**Addendum No. 1**

RE: Contract ID: C201733

**Caldwell County (B-4054)**

Bridge over Yadkin River and Approaches on SR-1517

PROJECT REFERENCE No. B-4054	SHEET No. 3
---------------------------------	----------------

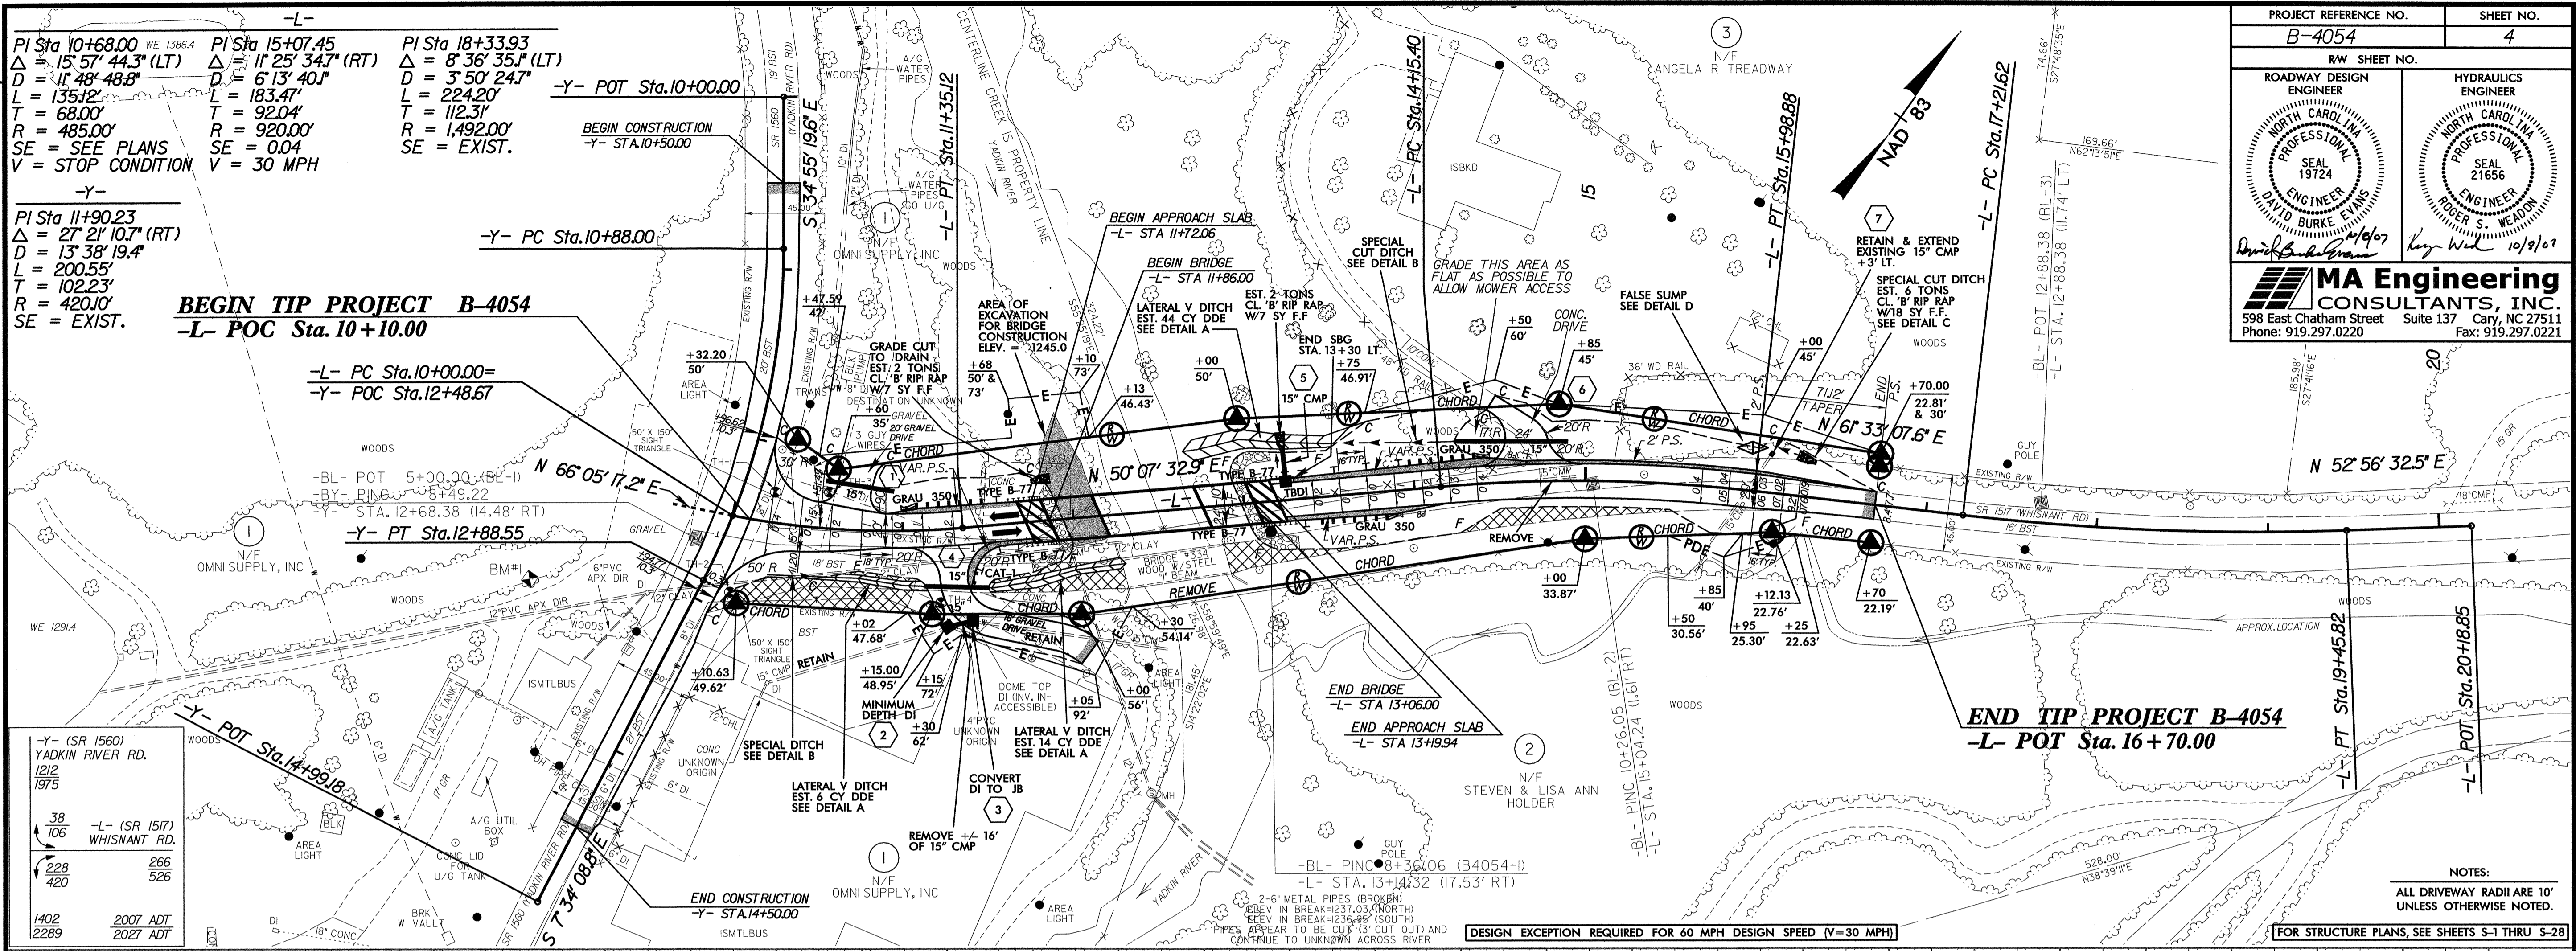
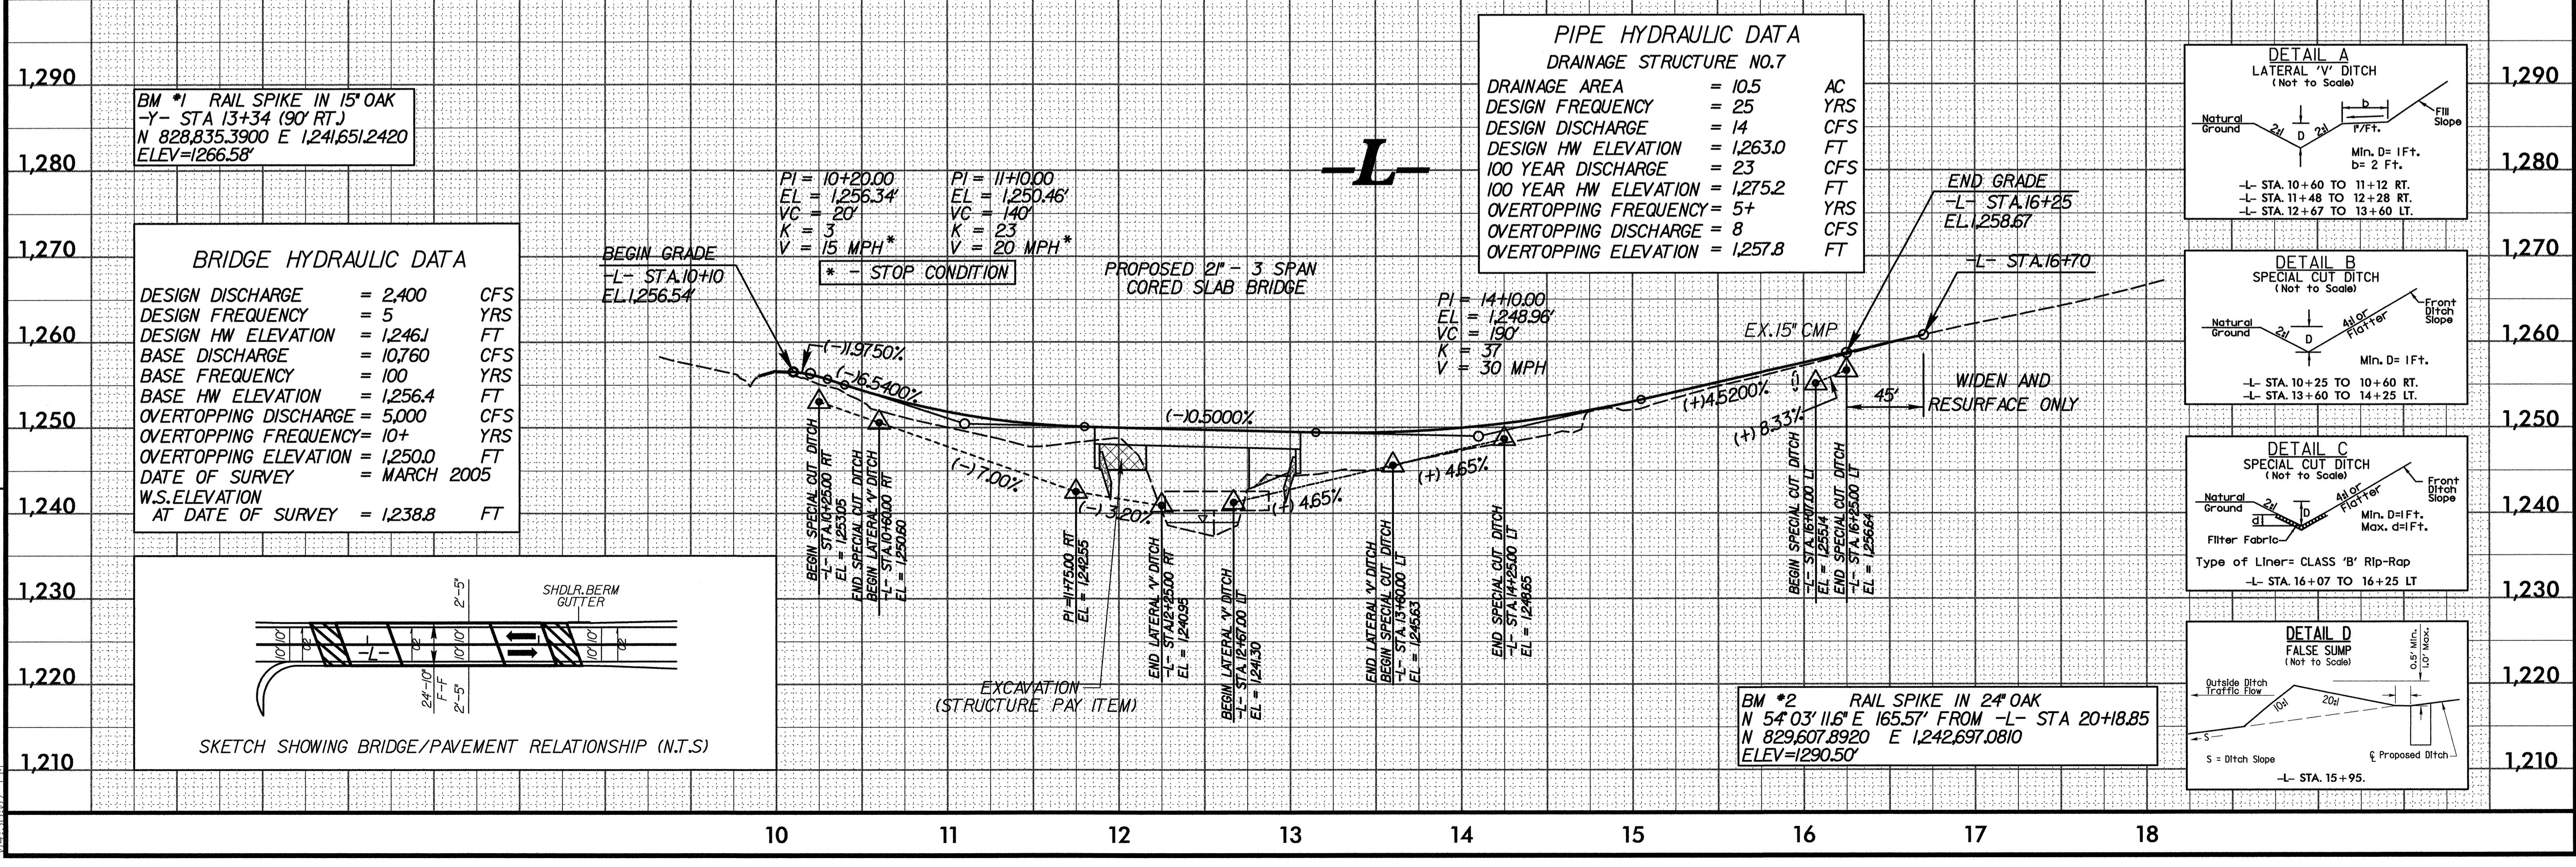
On Page No. 1 of the item sheets, by copy of this addendum the following line item is hereby deleted: "2-0000400000-N-801 Construction Surveying (Quantity = Lump Sum)".

Sheet No. 3 has been revised to reflect the above noted change. Please void Sheet No. 3 in your plans and staple the revised Sheet No. 3 thereto.
